Appeal Decision

Appeal Ref: APP/R5510/D/22/3304526

146 Swakeleys Road, Ickenham UB10 8BA

- The appeal is made under section 78 of the Town and Country Planning Act 1990 against a refusal to grant planning permission.
 - The appeal is made by Mr Kooner against the decision of the Council of the London Borough of Hillingdon.
 - The application Ref 76229/APP/2022/898, dated 16 March 2022, was refused by notice dated 12 May 2022.
 - The development proposed was originally described as 'construction of in and out driveway'.
-

SIDE ELEVATION from 144

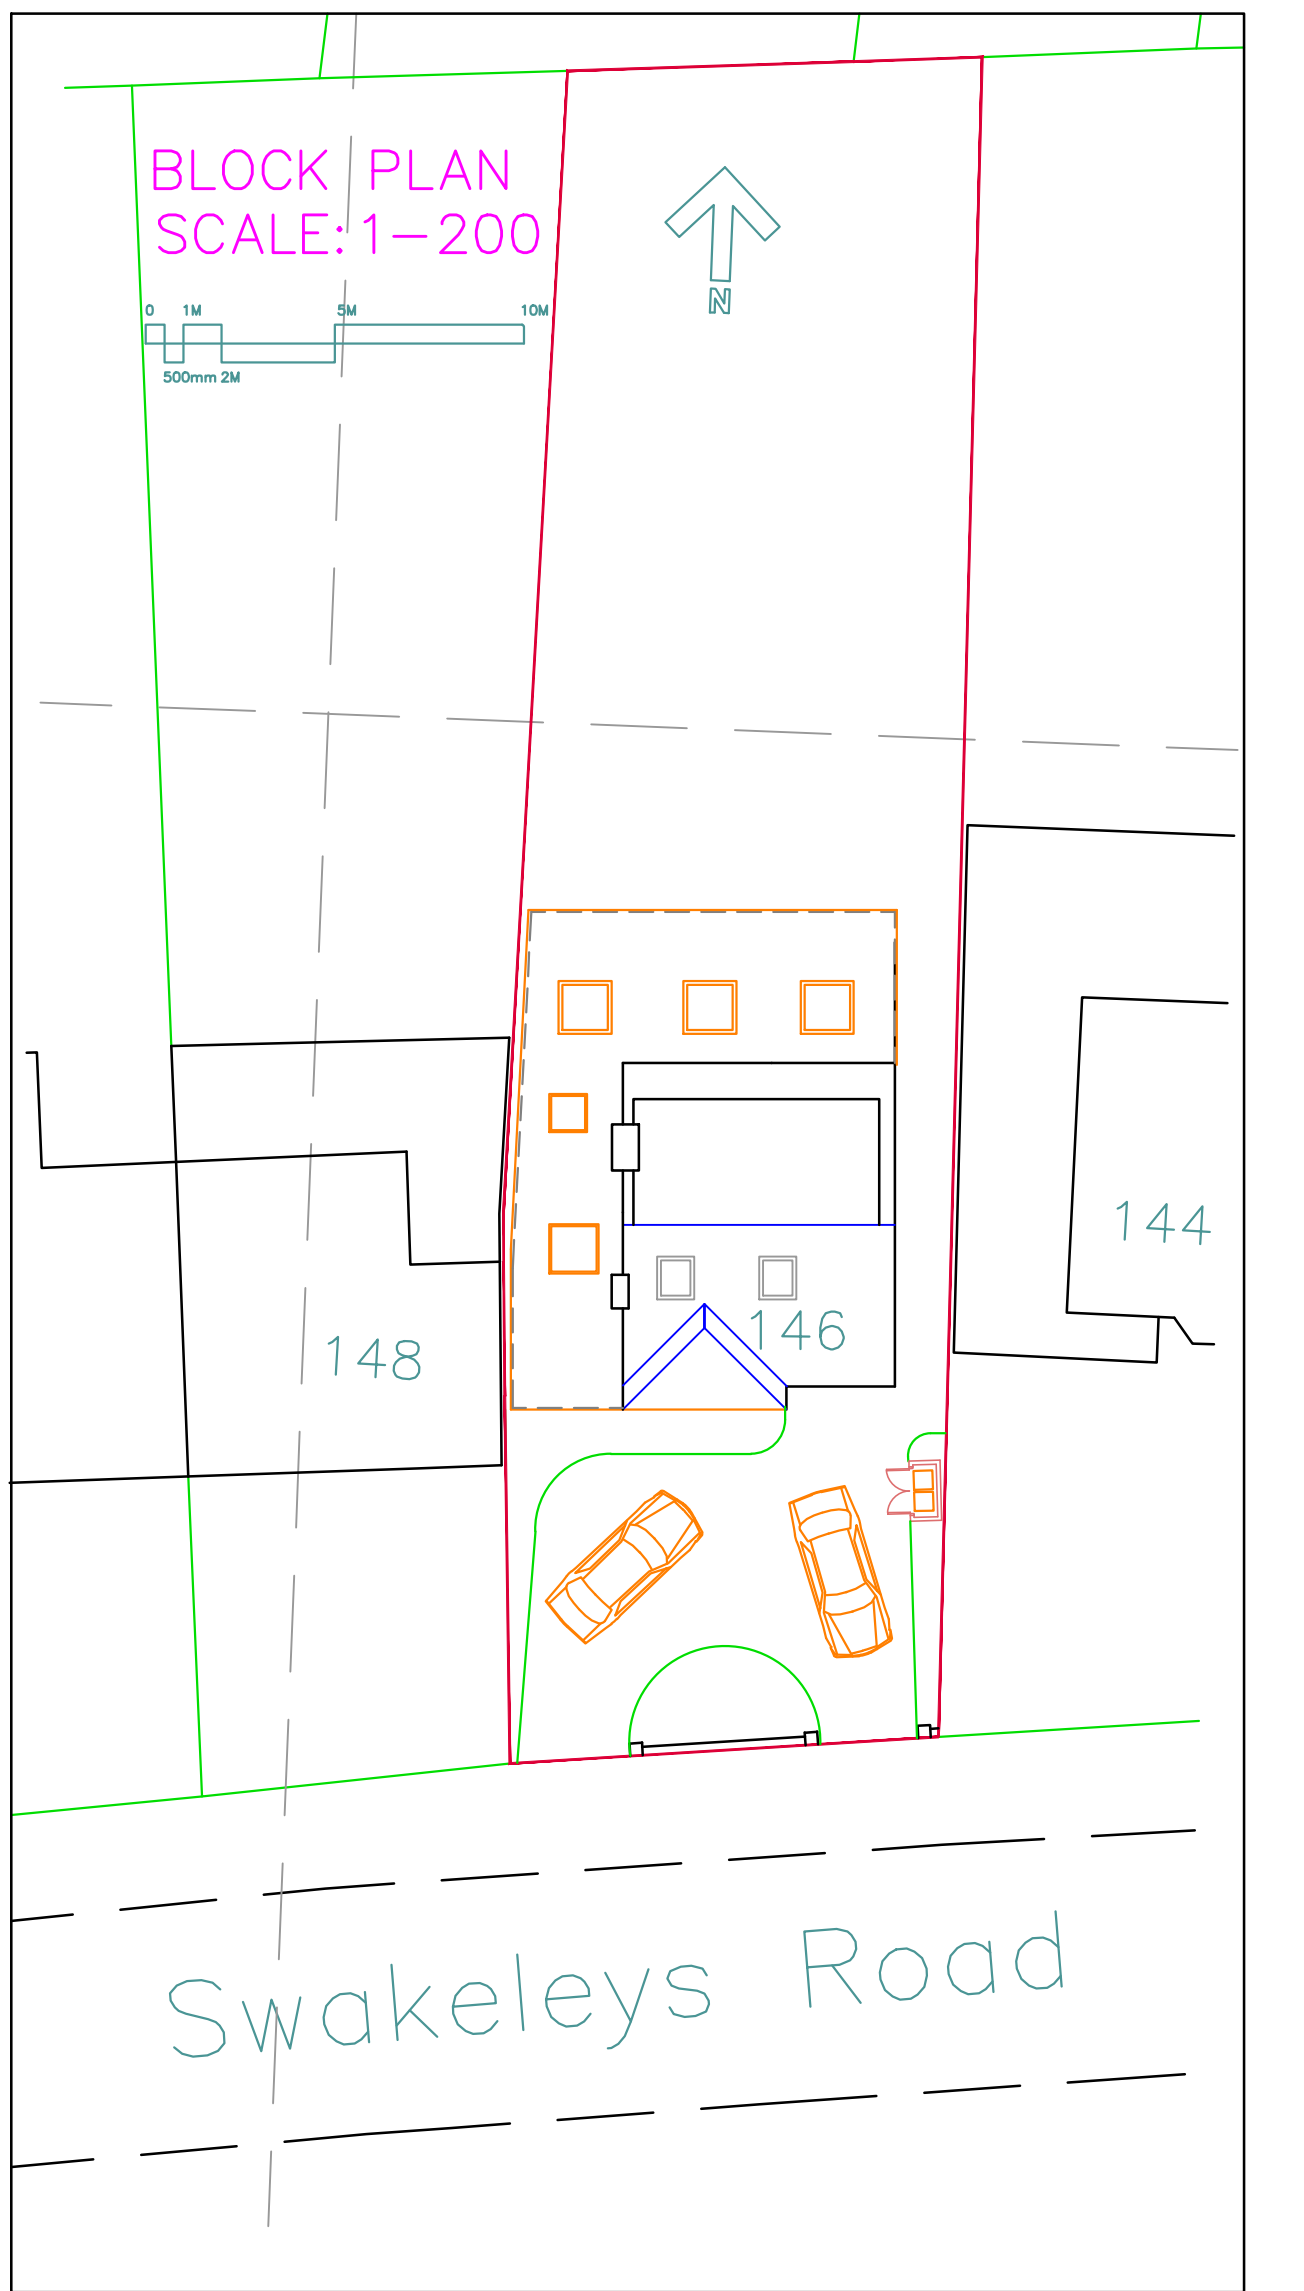
4. The appeal site includes a detached dwelling with hardstanding used for parking to its frontage. There is an existing vehicular access to the site close to the boundary with 148 Swakeleys Road which is served by a dropped kerb that also serves this neighbour. The appeal proposes a second vehicular access close to the boundary with 144 Swakeleys Road. This would be served by an extension of the existing dropped kerb that provides access to No 144.

5. There is no dispute between the main parties that the appeal site is less than 12m wide at the highway. The shortfall would be small, but the proposal would not therefore accord with the requirement within the Domestic Vehicle Footway Crossover Policy 2019 ('DVFC') for the property frontage abutting the highway to be at least 12m wide for a second crossover to be permitted.

6. Based on my observations at my visit however, turning vehicles within the site would be likely to be difficult given the dimensions of the site frontage, and would require multiple manoeuvres at the very least. This would not be convenient, and is likely to result in vehicles reversing either into or out of the site. As it passes the site, Swakeleys Road is a dual carriageway and Classified Road. At the time of my visit, I noted a fairly steady flow of traffic, and my impression was that most vehicles were travelling at or around the 30mph speed limit, if not faster. I acknowledge that this is only a snapshot, but given these conditions, it seems to me that there would currently be potential for conflict between vehicles reversing to or from the site and other highway users to the detriment of safety. The appeal proposal would provide for an 'in and out' arrangement that would enable vehicles to more easily enter and exit the site in a forward gear. In my judgement, this would be likely to reduce potential for conflict with other users of the highway and pedestrians in comparison to the existing arrangement, with an overall benefit to safety.

7. The proposed crossover would adjoin that of No 144 with no separation, but the width of the combined flat section to the crossover would not exceed the standards indicated within the DVFC for two adjoining crossovers, including where a new crossover is proposed to join an existing one. In addition, the likelihood of vehicles seeking to enter or exit the appeal site and No 144 at the same time would be very small given the size of the dwellings and parking areas so that the risk of conflict would be low. There would also be separation to the existing crossover on the site providing for a pedestrian refuge between the accesses, and this part of the street is relatively straight providing for good visibility. Consequently, I find that the combined width of the crossover would not result in any meaningful increase in potential for conflict with pedestrians, cyclists or other vehicles so as to harm safety.

1. The appeal is allowed and planning permission is granted for installation of a vehicular crossover at 146 Swakeleys Road, Ickenham UB10 8BA in accordance with the terms of the application Ref 76229/APP/2022/898 dated 16 March 2022 subject to the following conditions:
 - 1) The development hereby permitted shall begin not later than 3 years from the date of this decision.
 - 2) The development hereby permitted shall be carried out in accordance with the following approved plans: 3251-SK1, 3251-2-03, 3251-2-04 and 3251-2-05.
